DECISION DELEGATED TO HEAD OF PLANNING

Application No: H02-1008-25 **Applicant:** Mr M Blackbird
Proposal: Erection of 3 Dwellings with a Double Garage to Plot 3
Location: Land At Blackbird Close Crowland Peterborough
Terminal Date: 5th January 2026

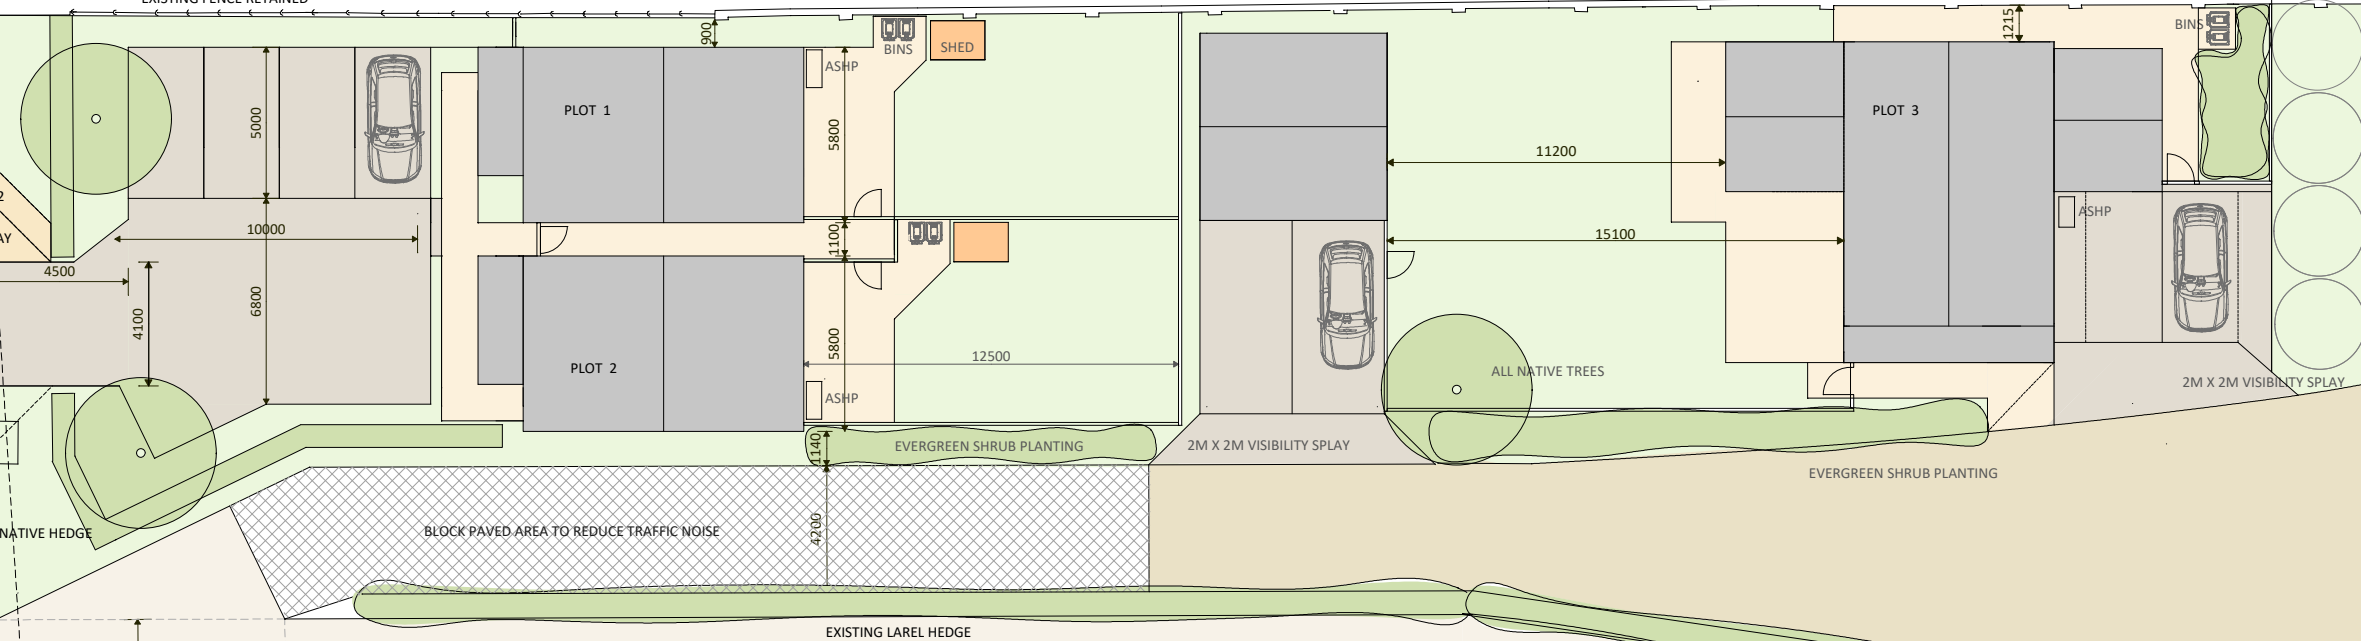
In this case, the proposed layout of the two frontage dwellings is driven primarily by the requirement to accommodate the internal driveway serving the rear plot. As a result, the frontage plots appear artificially constrained and uncharacteristically narrow in their relationship with one another. The dwellings are positioned in close proximity, creating a 'squeezed' form of development that contrasts unfavourably with the prevailing pattern of development along Peterborough Road, where properties typically benefit from more generous spacing and a clearer sense of individual plot identity.

This harm is compounded by the significant set-back of the dwellings from the highway, which disrupts the established building line and weakens the sense of enclosure and rhythm along the street. The introduction of a shared, pool-style parking area to the front of the site further erodes the residential character of the frontage, introducing a visually dominant and car-led feature that would be readily apparent within the street scene. Taken together, the layout, spacing and parking arrangement would result in an incongruous frontage that fails to integrate successfully with the surrounding built form.

The proposal would locate Plot 3 in close proximity to No. 4B Kennulphs Close, resulting in an overbearing relationship with the neighbouring dwelling. The siting and scale of the proposed building would significantly reduce the sense of openness currently enjoyed by the occupiers of No. 4B and would result in periods of overshadowing to parts of the neighbouring rear amenity space and side elevation, thereby impacting upon its residential amenity. This impact is further exacerbated by the location of the proposed BNG gain.
